## WEST SUSSEX COUNTY COUNCIL CONSULTATION

| <b>LOCATION:</b>                | Land south of, New Road (A259) & East of Brook, Angmering                                                                                                                                                                                                                                                                                                                                                                                 |
| <b>SUBJECT:</b>                 | A/11/17/OUT<br>Hybrid Application to include Full planning permission for a retail unit (Class A1) comprising 1,487sqm with associated access, car parking, servicing, landscaping & associated works & Outline planning permission with some matters reserved (scale & appearance) for public house (Class A4) comprising 581sqm (resubmission following A/23/15/OUT).<br><br>This application is a Departure from the Development Plan. |
| <b>RECOMMENDATION:</b>          | <input type="checkbox"/> Advice <input checked="" type="checkbox"/> Objection<br><input type="checkbox"/> Modification <input type="checkbox"/> No Objection<br><input type="checkbox"/> More In

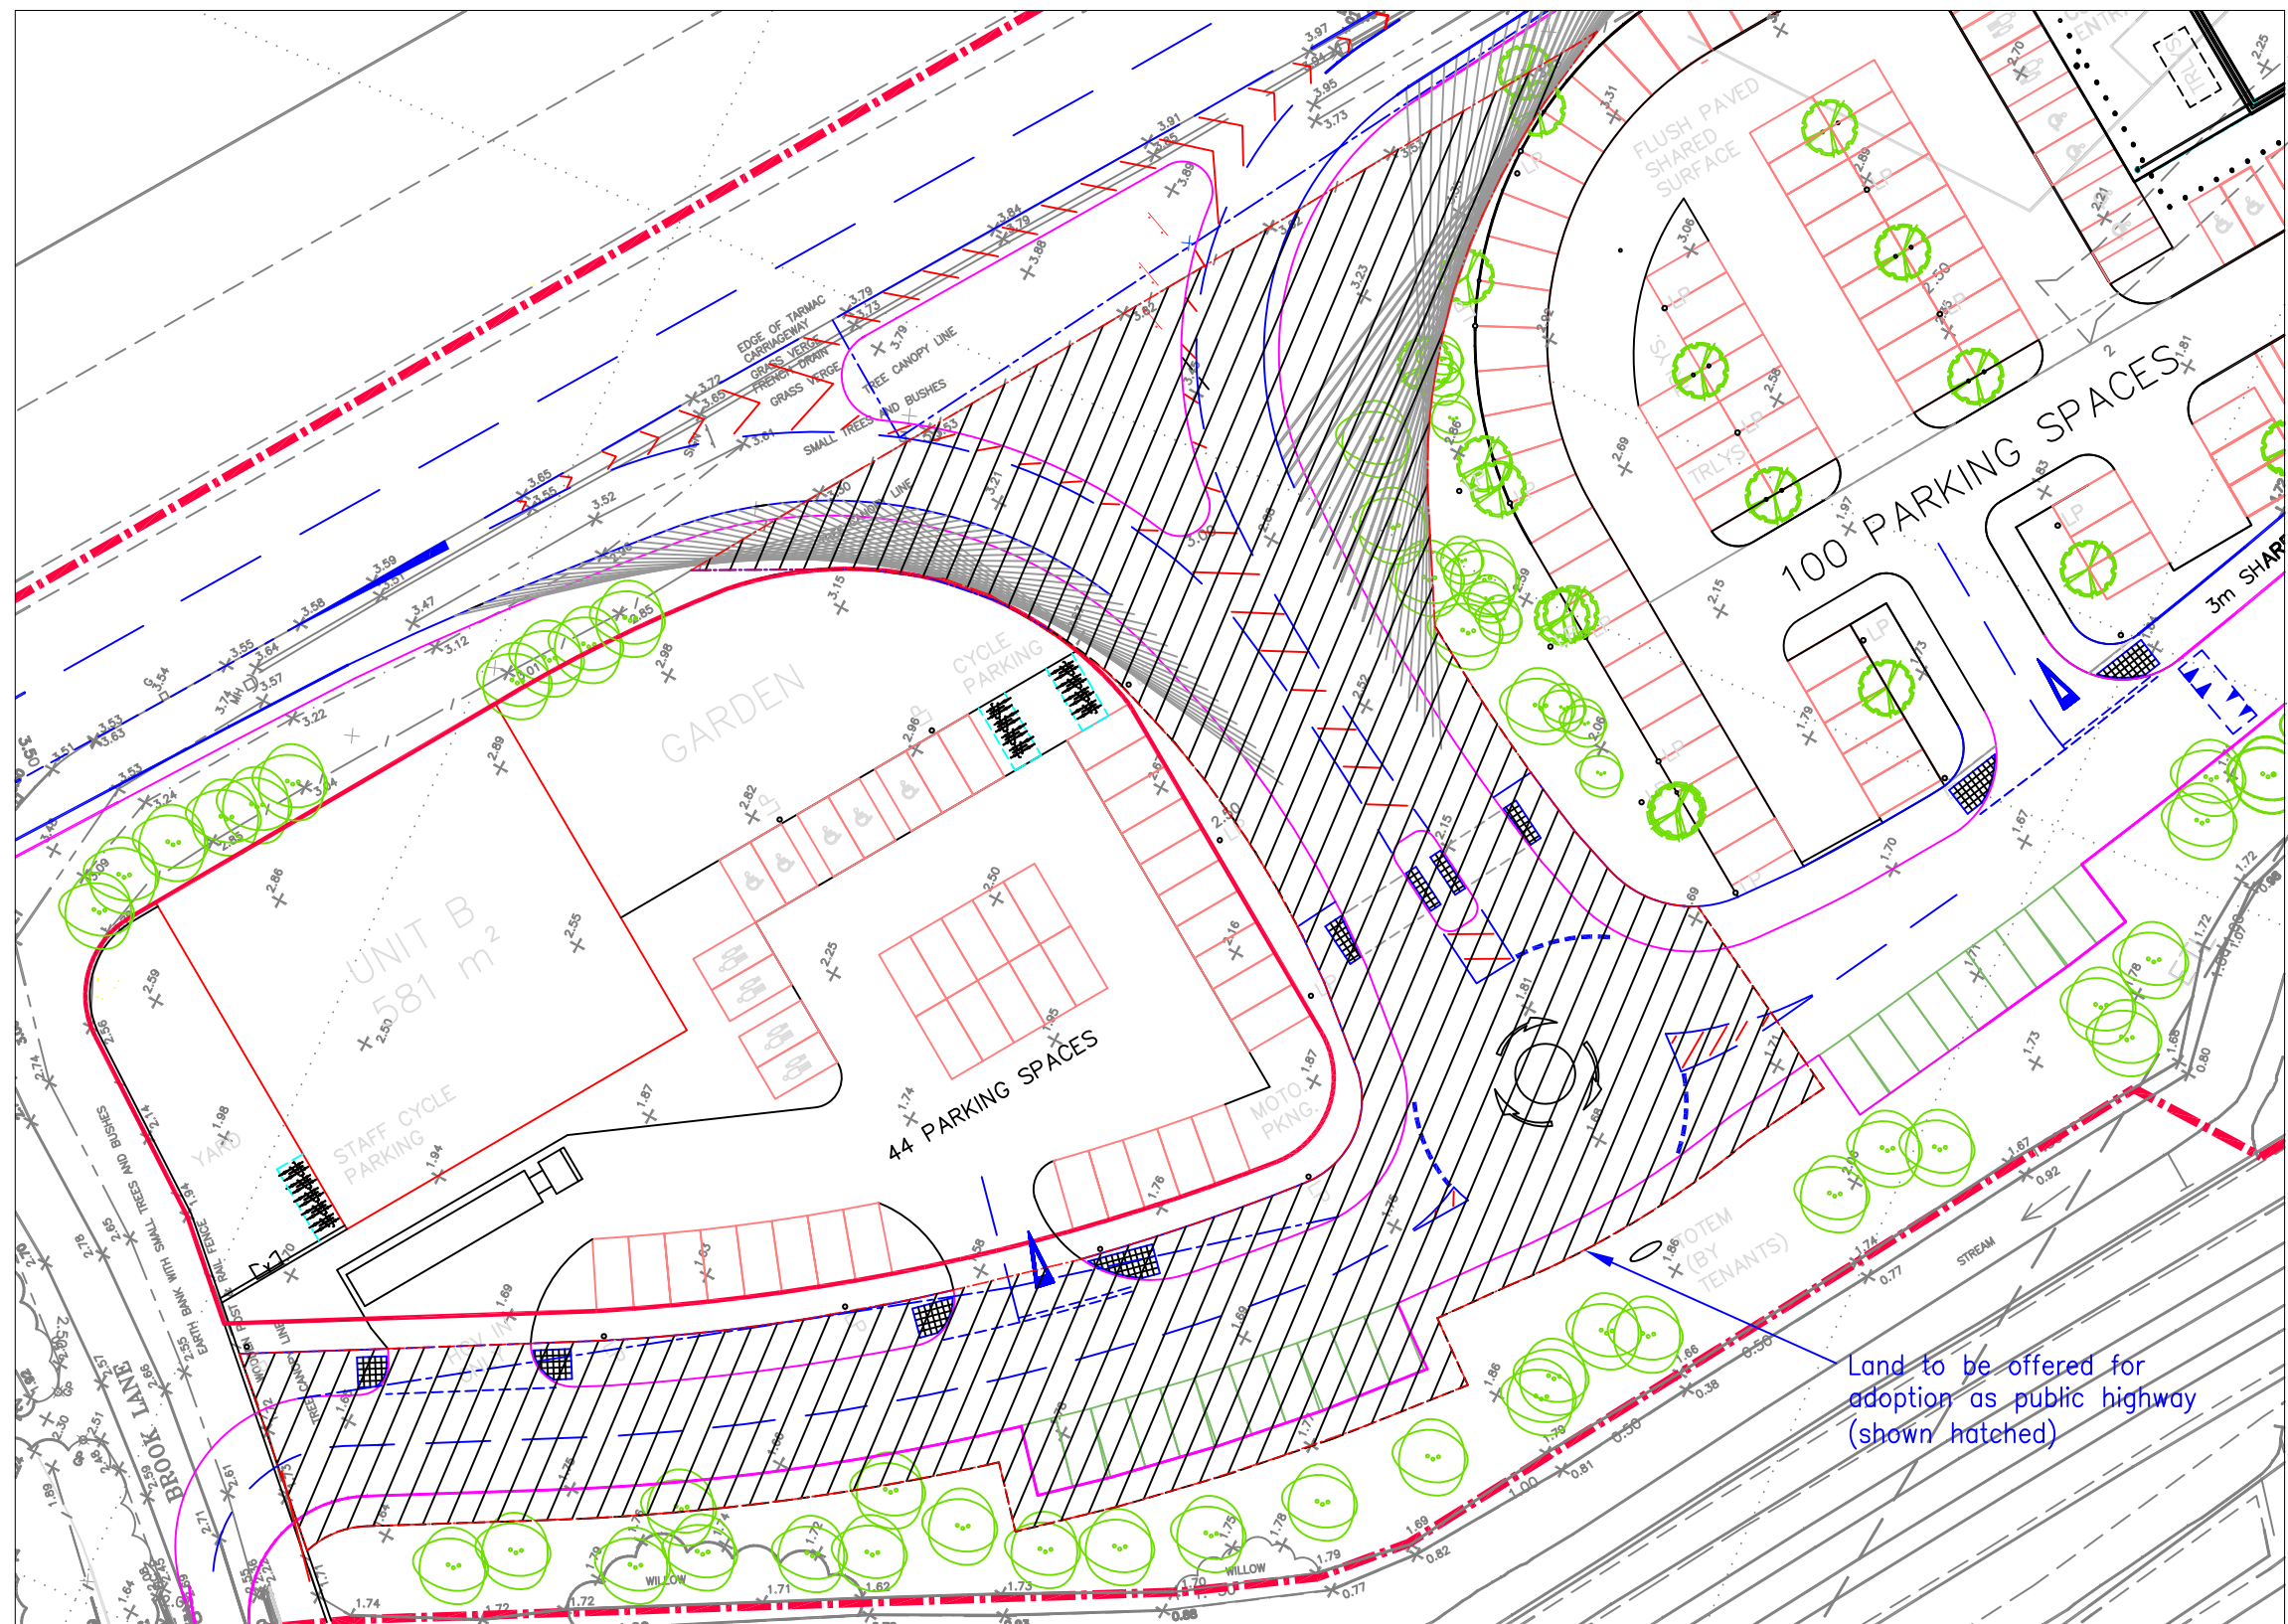
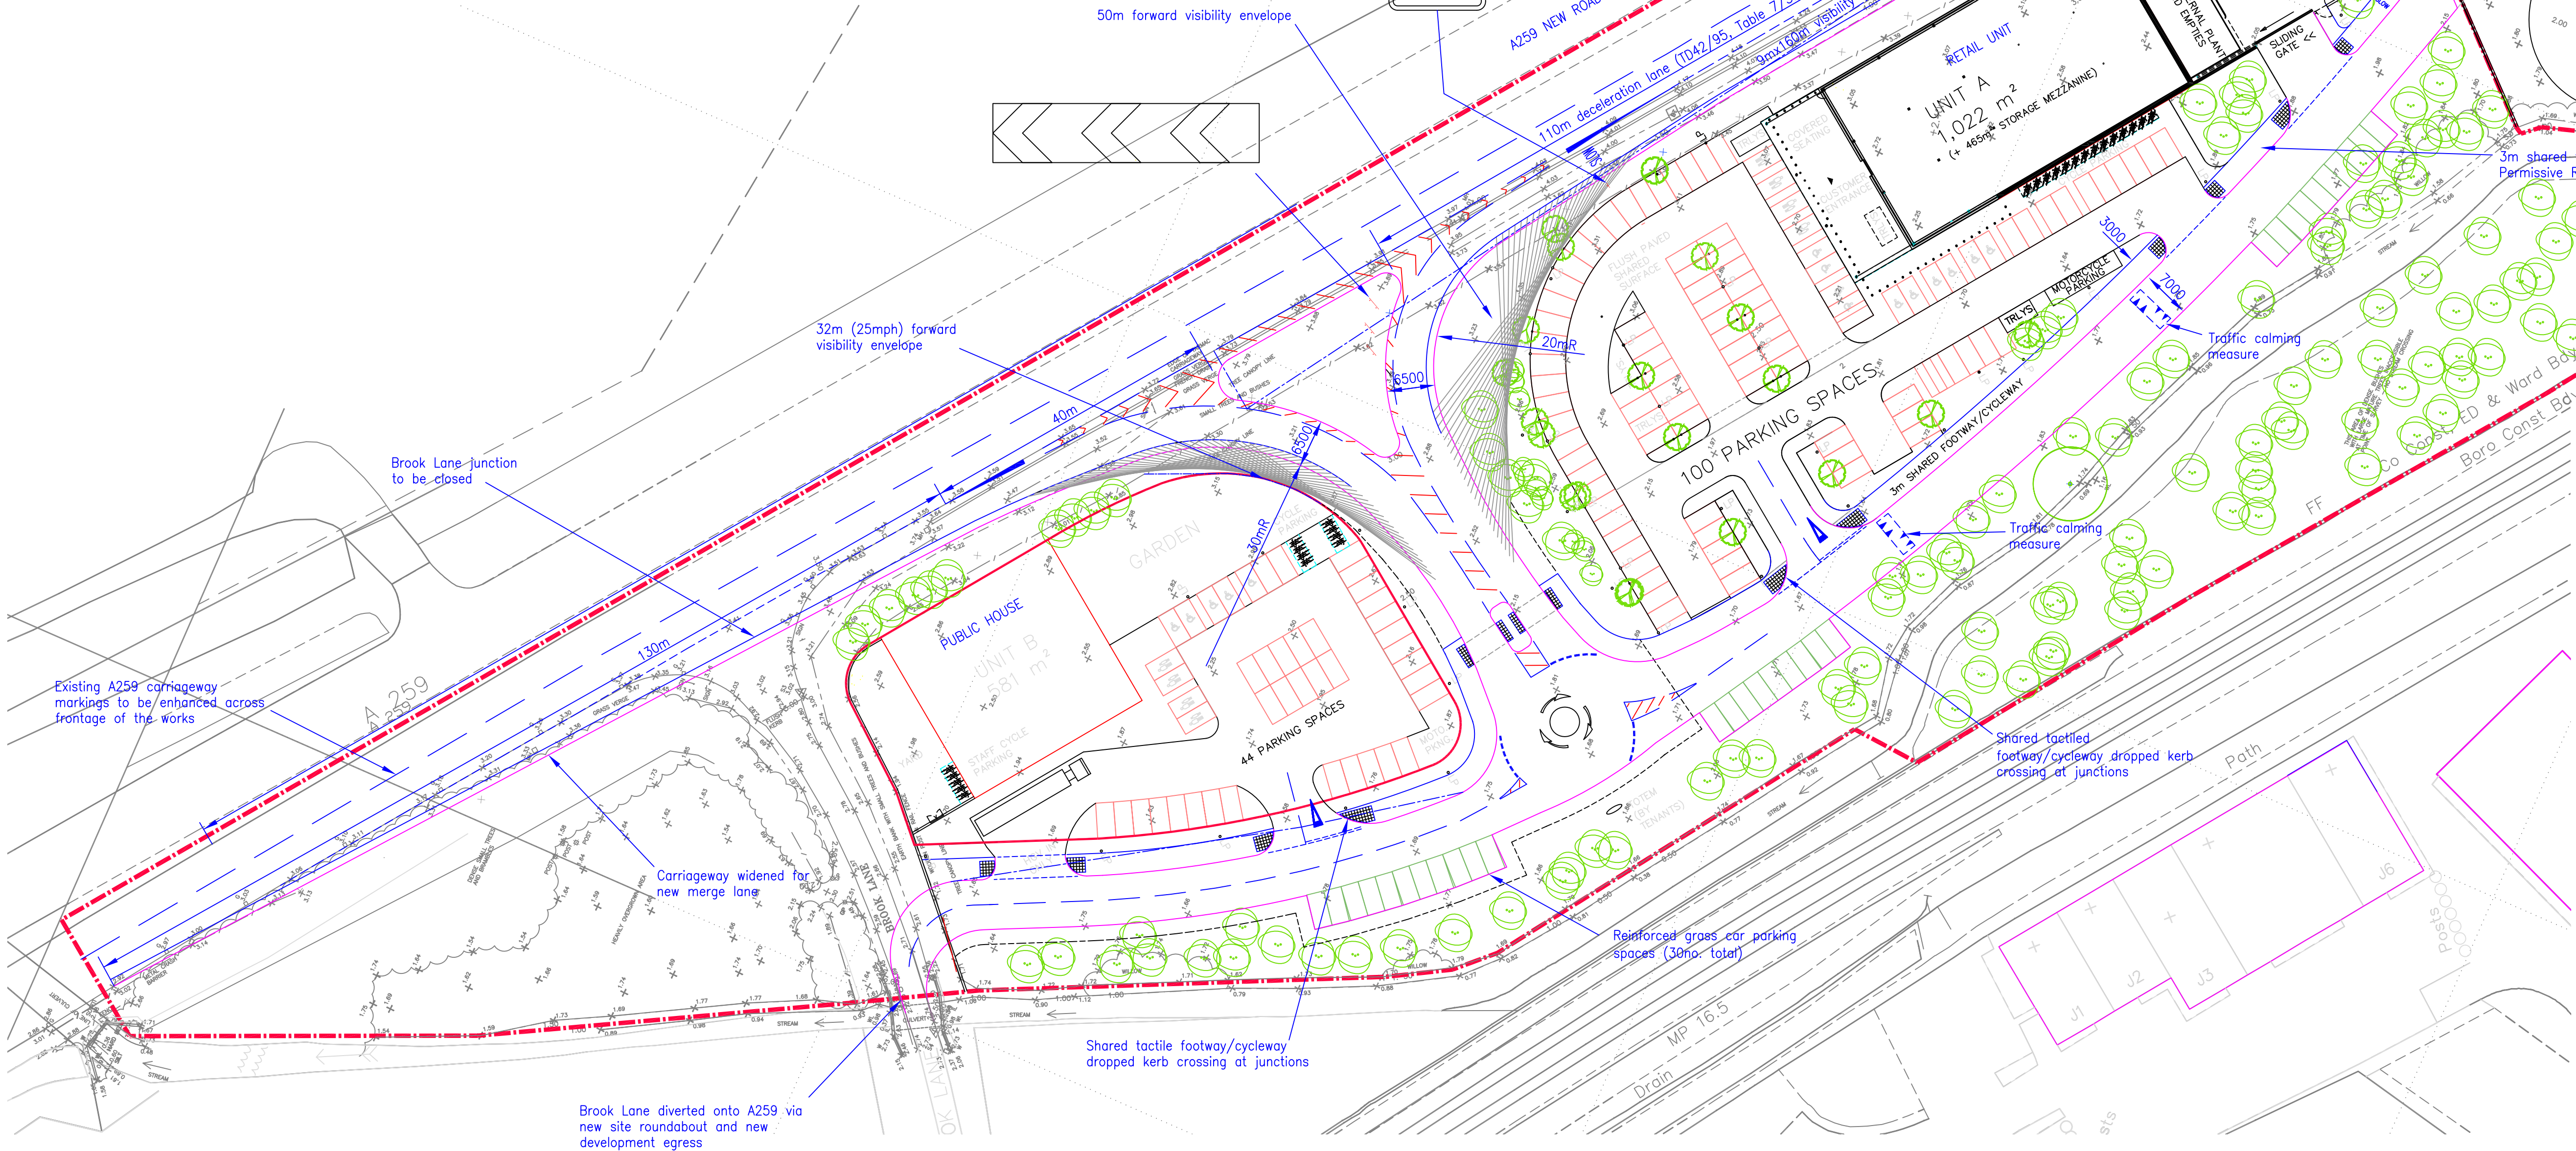
Given the approval of the site accesses associated with applications A/23/15/OUT and A/83/18/RES the applicant for application A/11/17/OUT has failed to demonstrate that they can deliver a safe access to the site whilst not prejudicing the committed development A/83/18/RES from coming forward. The local of the access would impact upon the deceleration lane proposed to serve applications A/83/18/RES and A/23/15/OUT. In light of the WSCC as Highway Authority objects to the planning application.
